Ann Machado - Re: Addendum for 125 sherwood street permit # 2014-00845

125 Sherwood St.
Permit # 2014-00845

A3.005

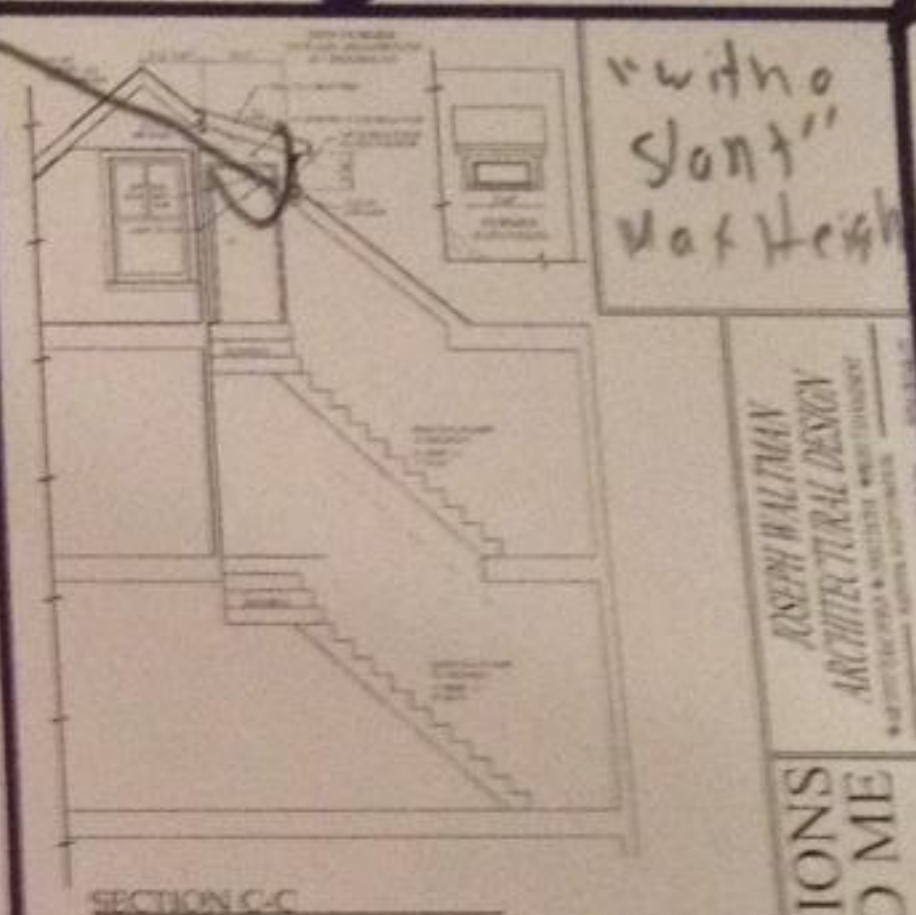
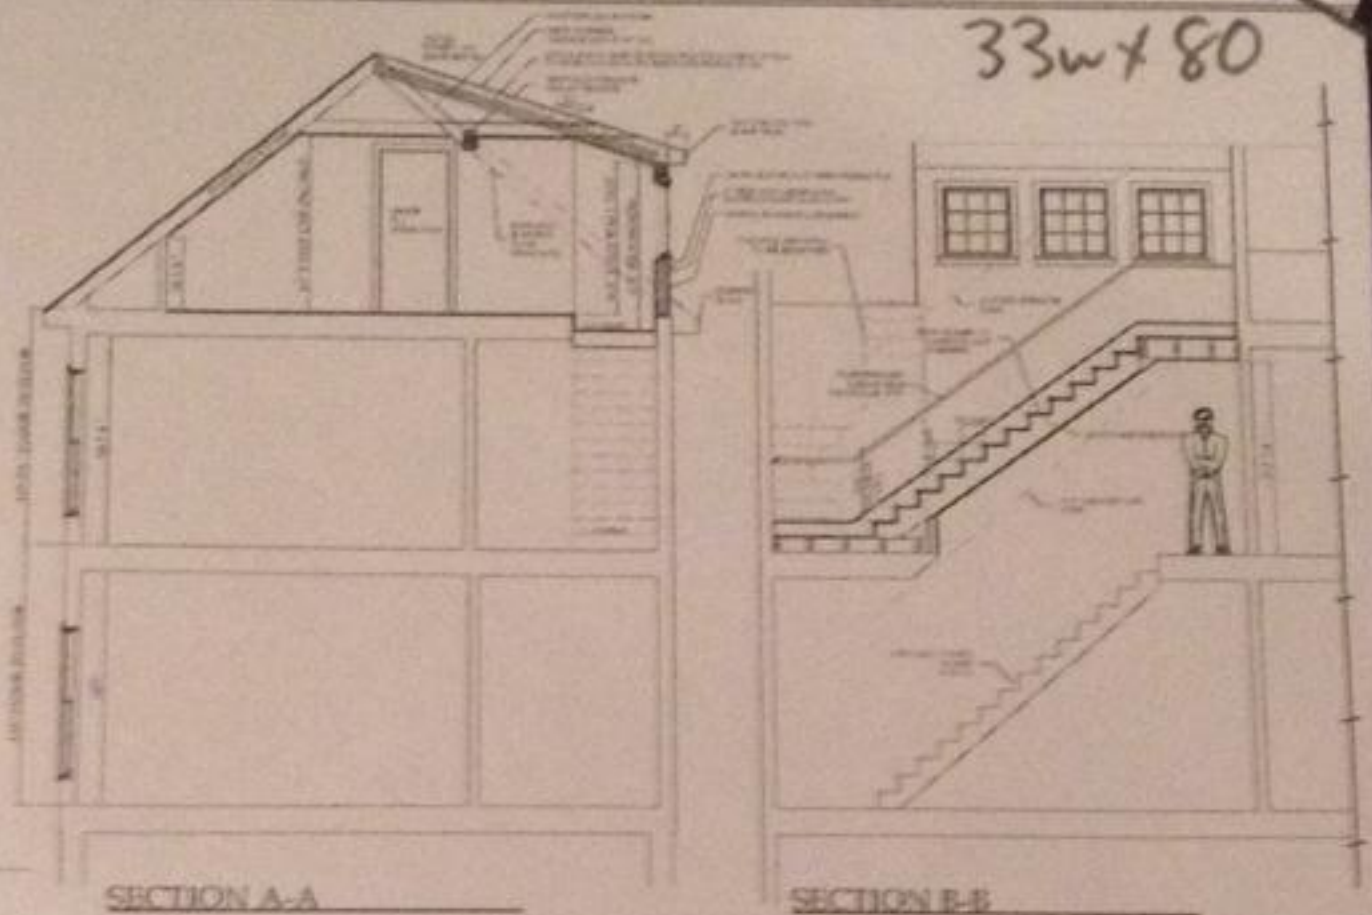
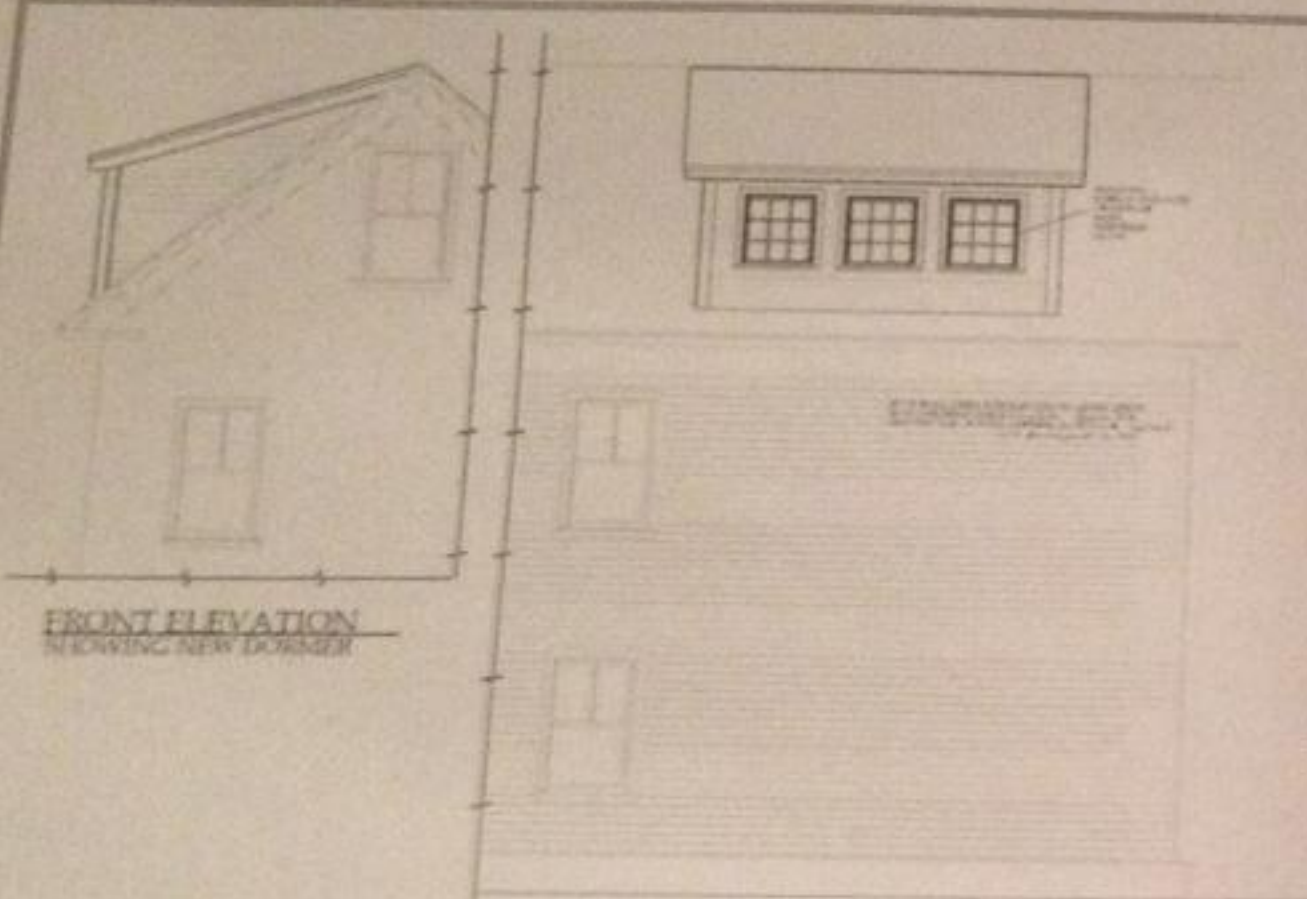
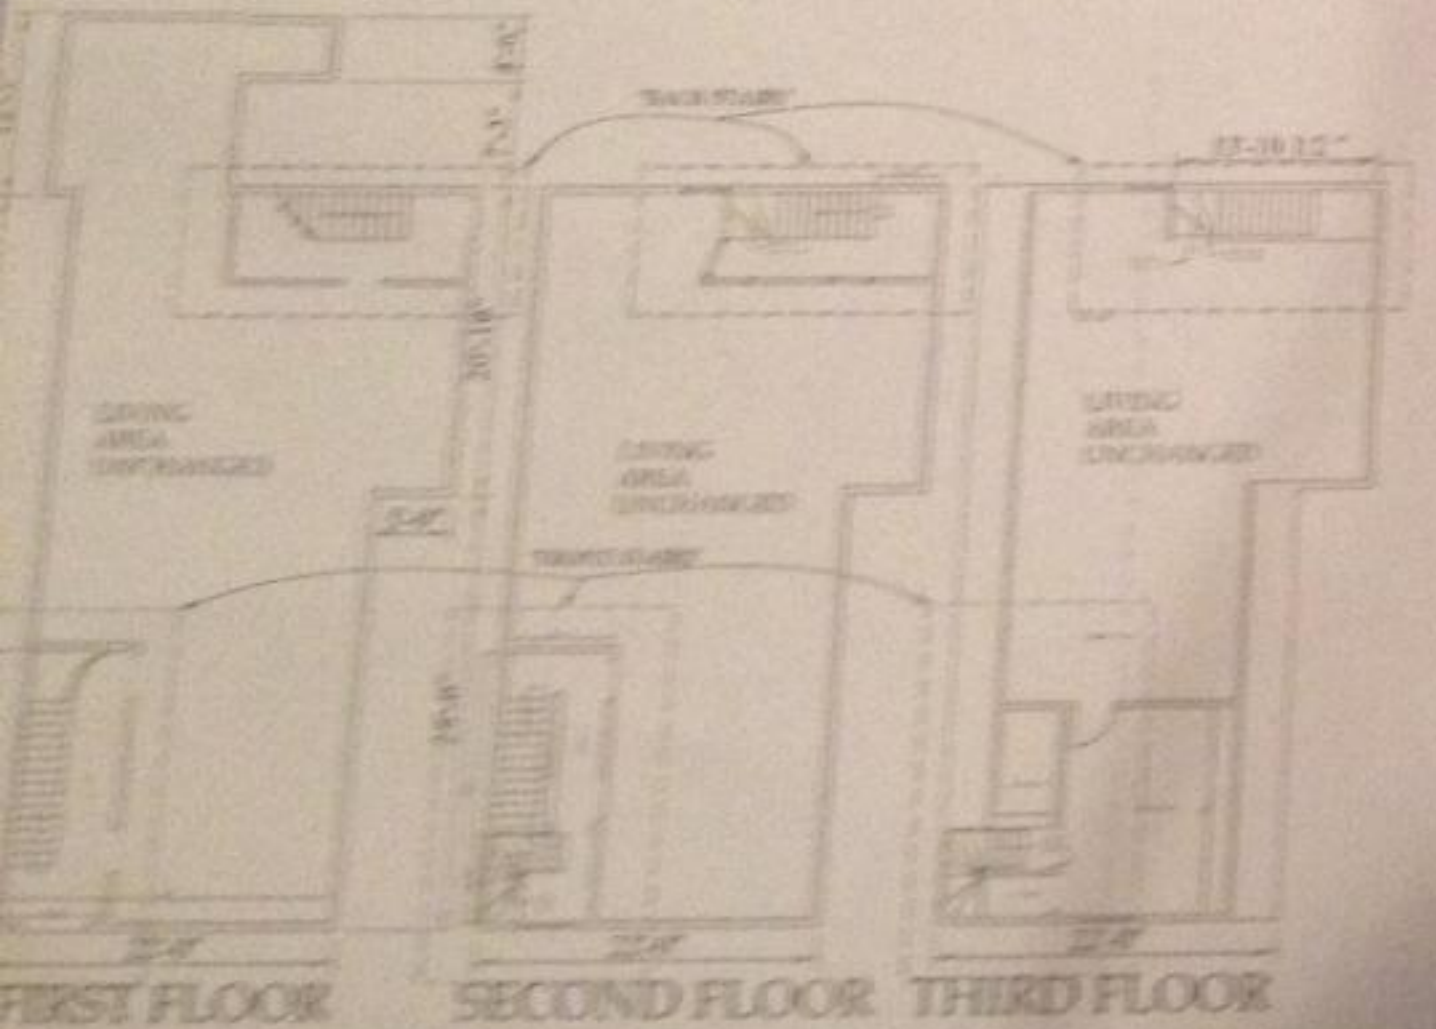
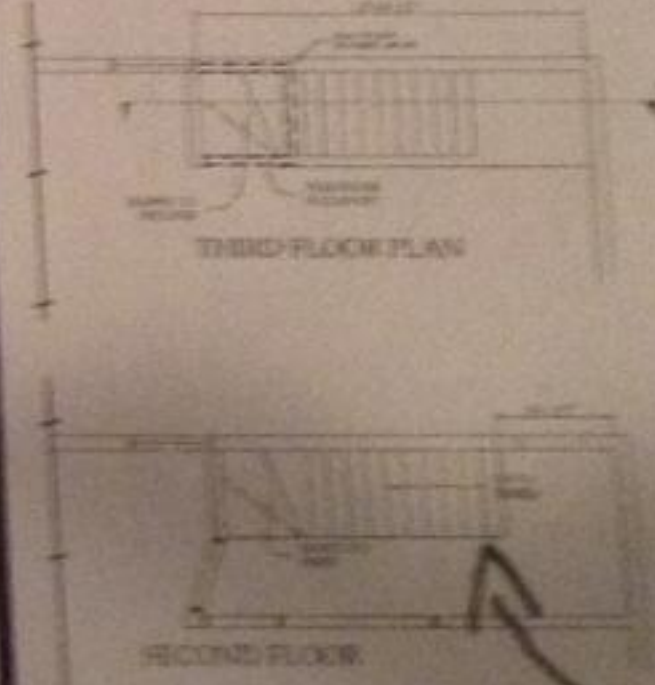
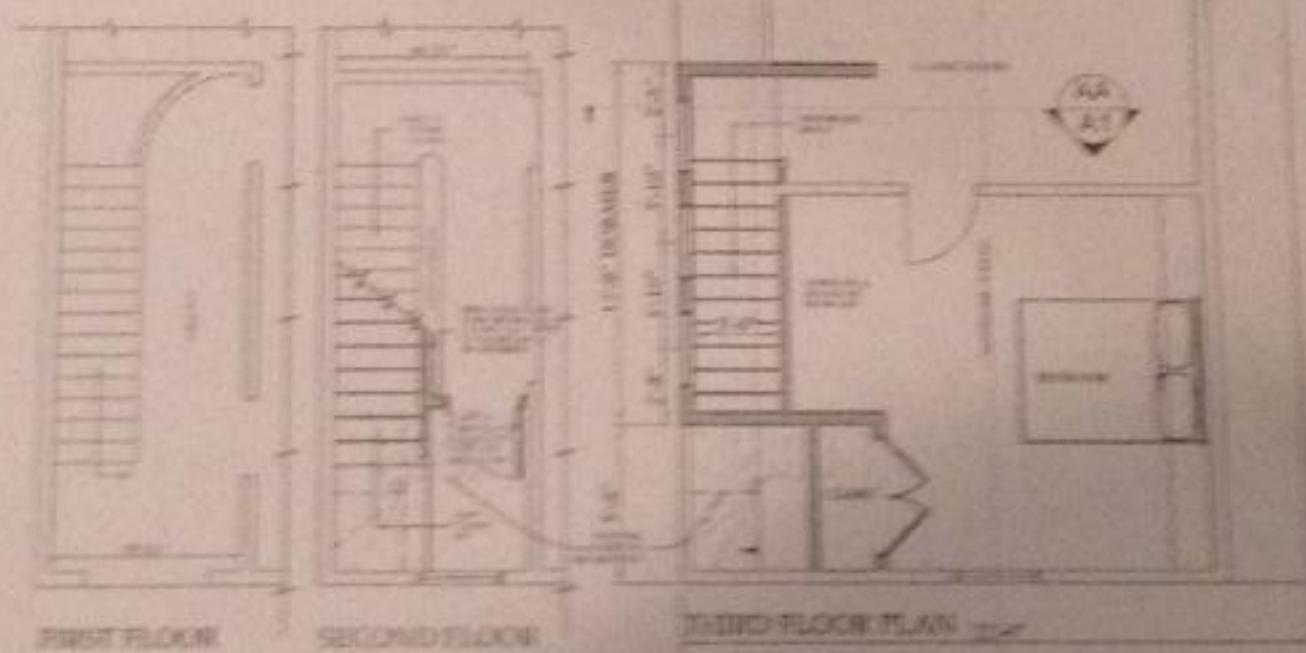
1. Instead of raising the roof and inserting a dormer to provide adequate height for a fire door we would install a fire door at the bottom of the stairwell and leave the existing door as open space. The open space is 33" w x 80" h. There is a slant in the opening, but since there wouldn't be a door it would actually be a bigger opening than if a gable was installed and a door put in. This option is considered the best by the construction workers and homeowner and much preferred. A couple pictures have been provided. Picture 1 demonstrates the opening where the previous door existed and would be left open. Picture 2 is at the bottom of the staircase where the new door would be installed.
